MEMORANDUM

FROM: Jim Wendel, Development Review Coordinator

DATE: December 24, 1996

RE: Request for Certificate of Occupancy
64 Felicia Lane (lot 13)

LOT 13
9983 S.F.

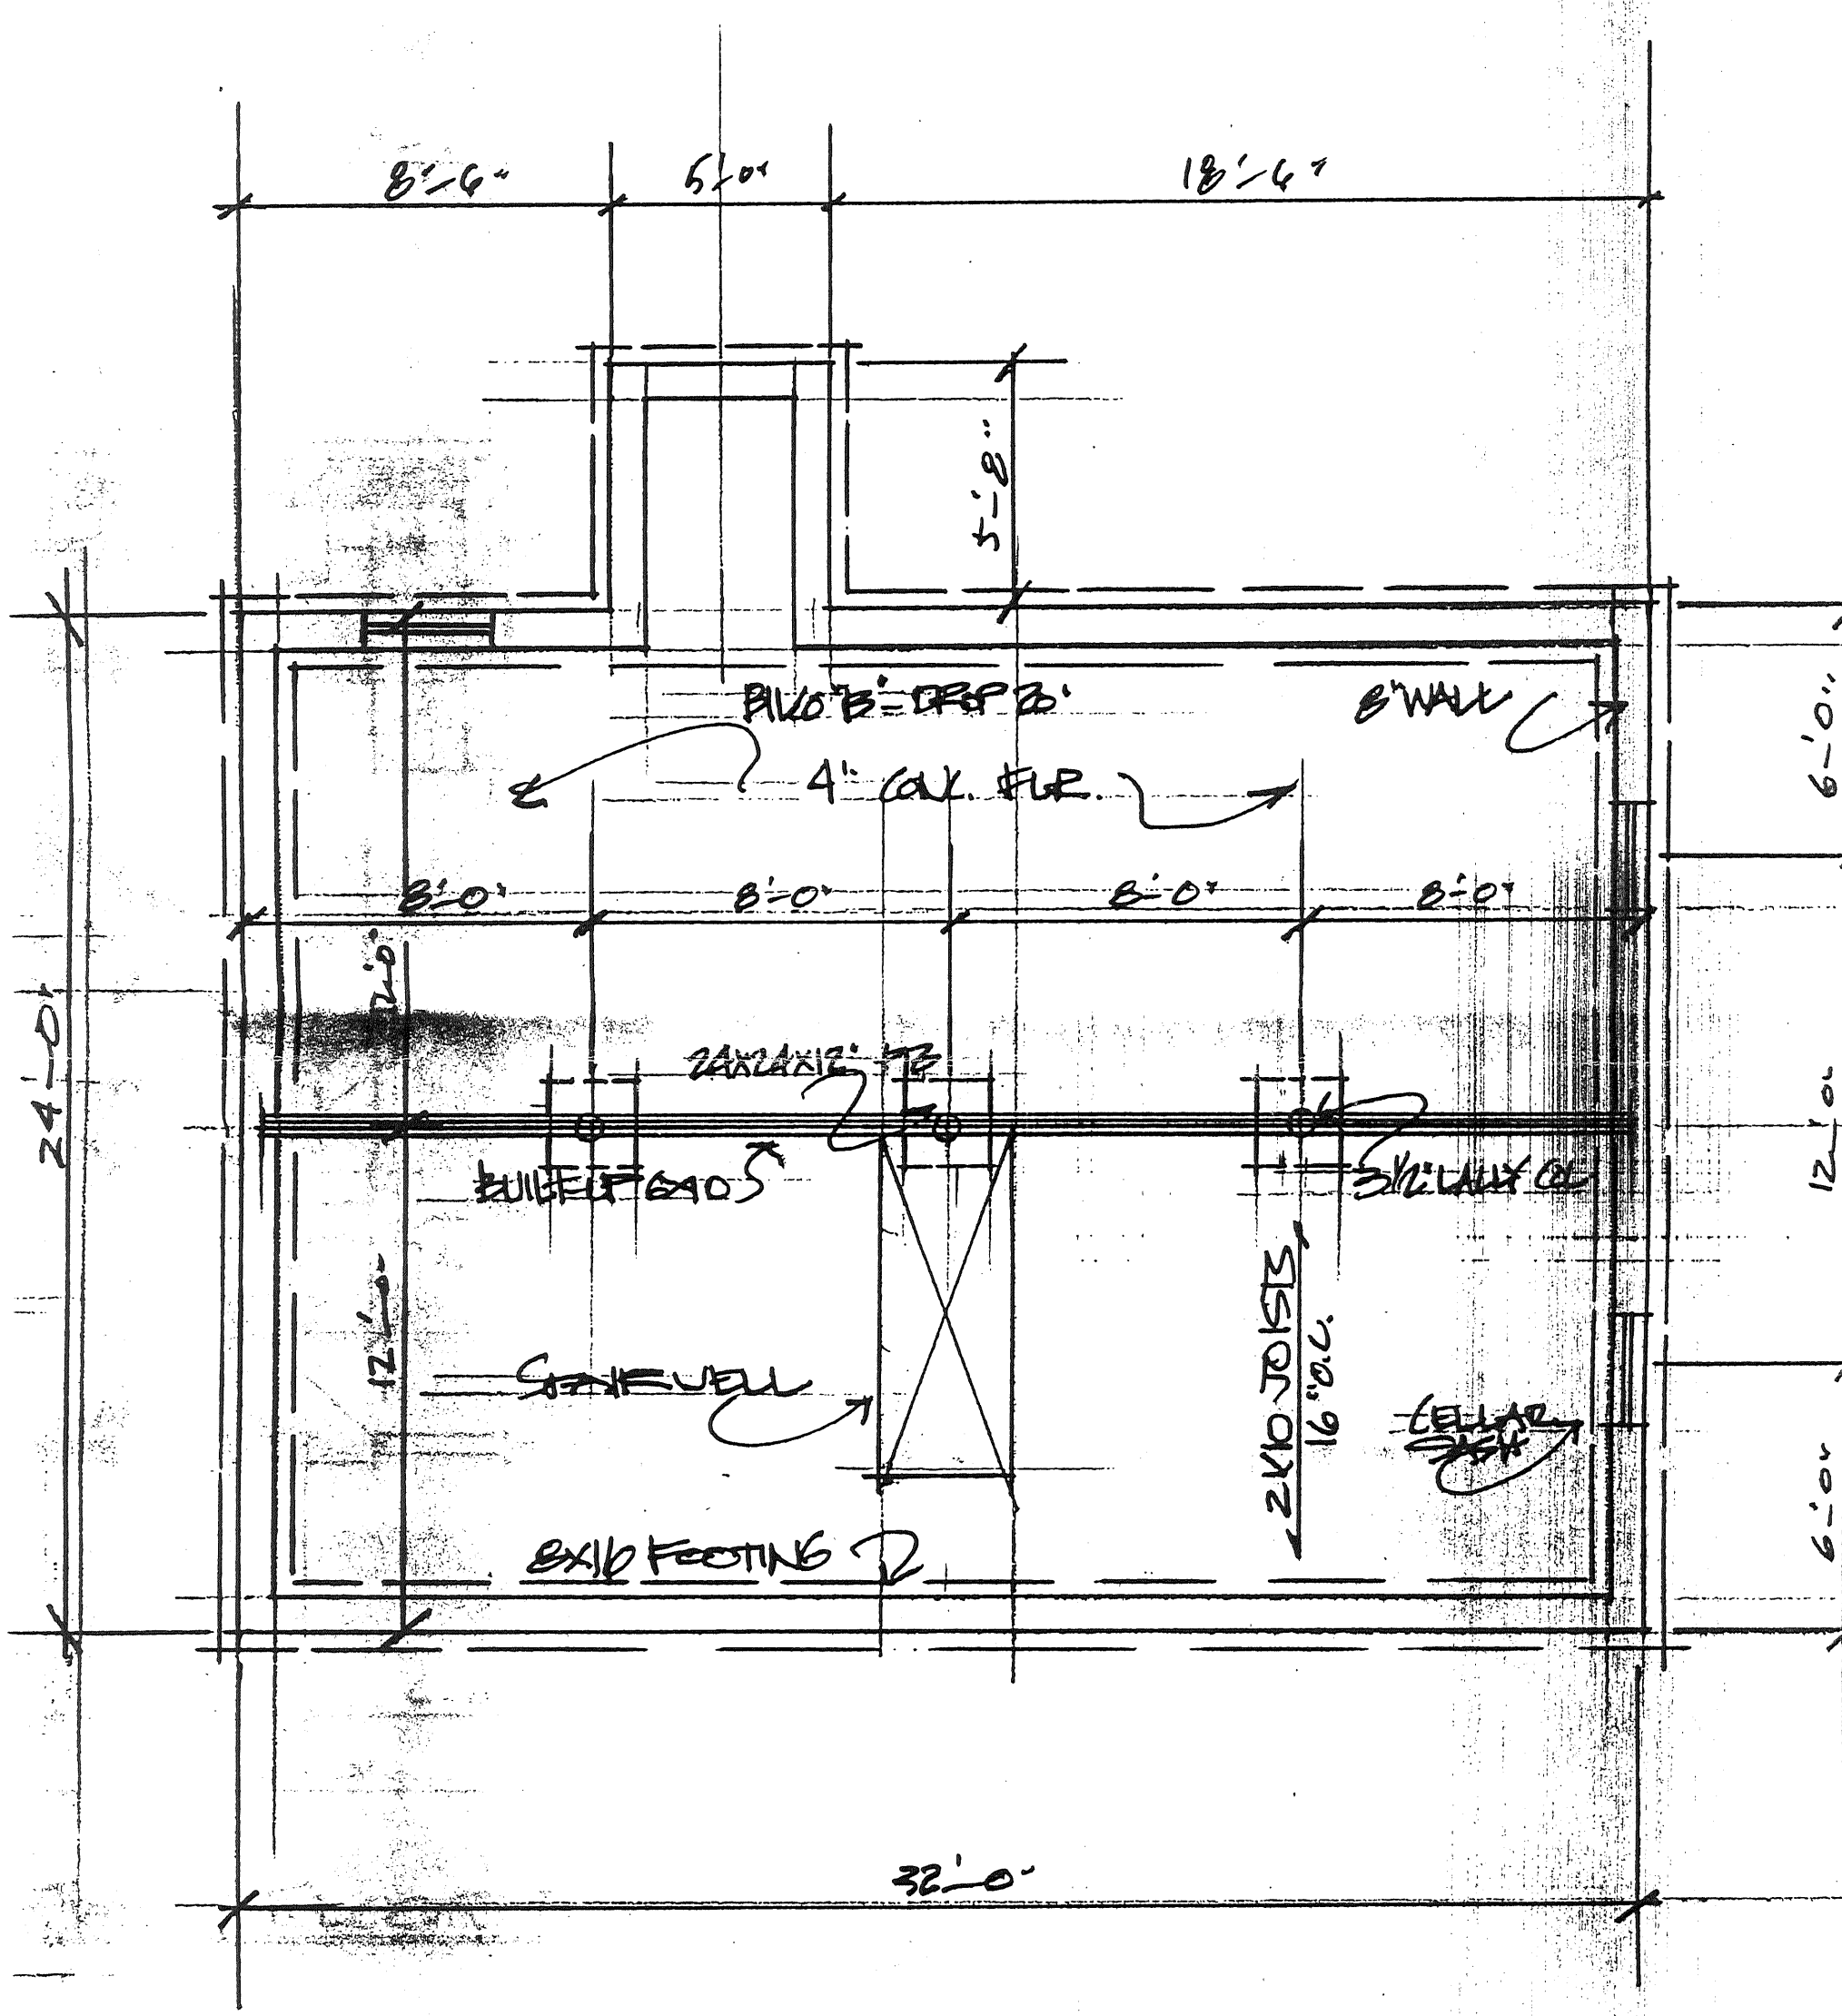
1. Significant ponding is occurring in the back yard; the applicant acknowledges the problem and has indicated that they have a contract with the homeowner to construct a garage for the house by June 1 of 1997 and they intend to correct the ponding.
4. The applicant must submit a copy of the sewer permit to the DRC as proof that Public Works has the as-built data for the storm and sewer services.
